From: East Preston Parish Council (SC) [REDACTED]
Sent: 24 May 2022 14:33
To: Obafemi Okusipe <Obafemi.Okusipe@arun.gov.uk>
Subject: RE: EP/39/22/PL - 29 Tamarisk Way

Subject: FW: EP/39/22/PL - 29 Tamarisk Way

Kindly find the agent's response to your comments on this application. The agent has provided drawings (below in this email) to illustrate or support their argument. Can you provide your final comments on this application in the light of the agent's inability to revert back to the chimney and browed eaves? Many thanks for your cooperation.

Proposed Roof Plan
1469/NA18A
Scale 1:100 at A3 .

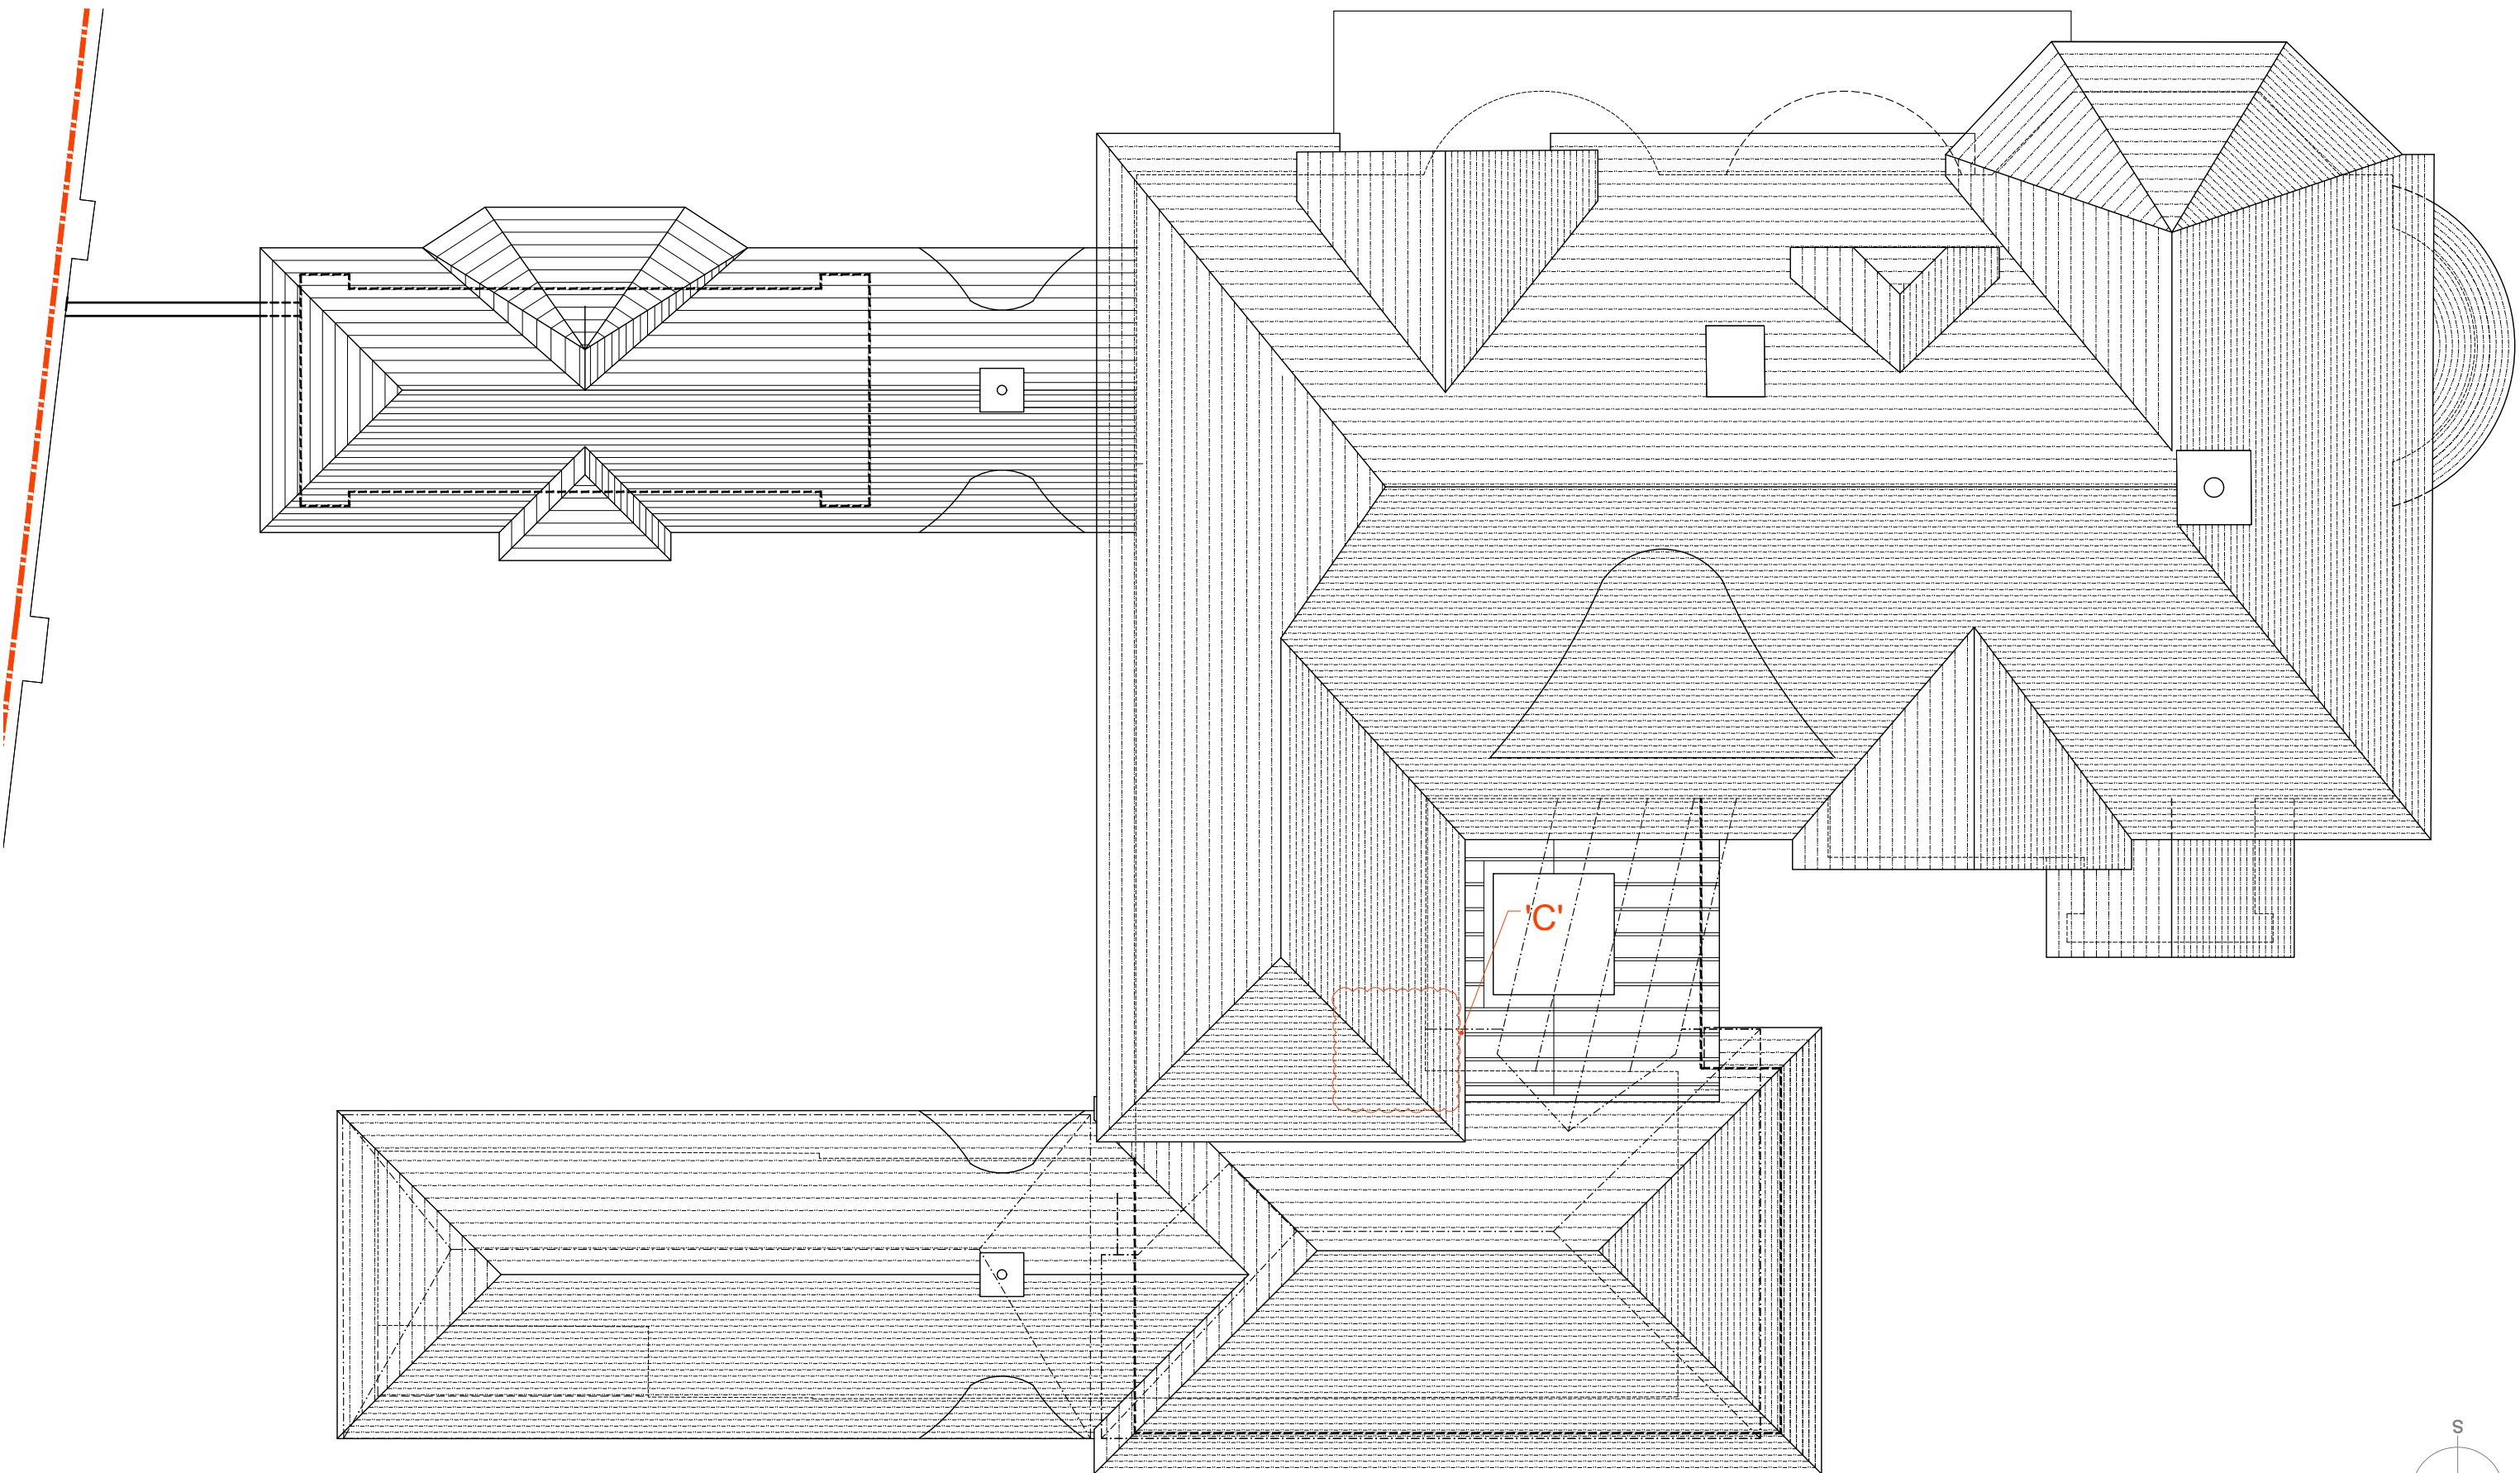
The committee appreciated the conversations the applicants have obviously had with Rebecca, but as no solutions have been found the council's comments stand.

Some committee members referred to Hascombe, next door in Tamarisk Way, and a property across the road from no. 29 where apparently solutions have been found to the problem of the eyebrow windows.

In terms of the chimney, this would only be visible on the east and west elevations, and would therefore not be visible from the road. It may be possible to briefly see these elevations from the south/the beach but due to the existing boundary hedgerow, this would be largely concealed. The chimney was removed as, internally, it was likely to require the removal of the only window to bedroom 5 which would be unacceptable (see snippet below). The loss of the chimney from the previously proposed in this instance is considered to be acceptable.
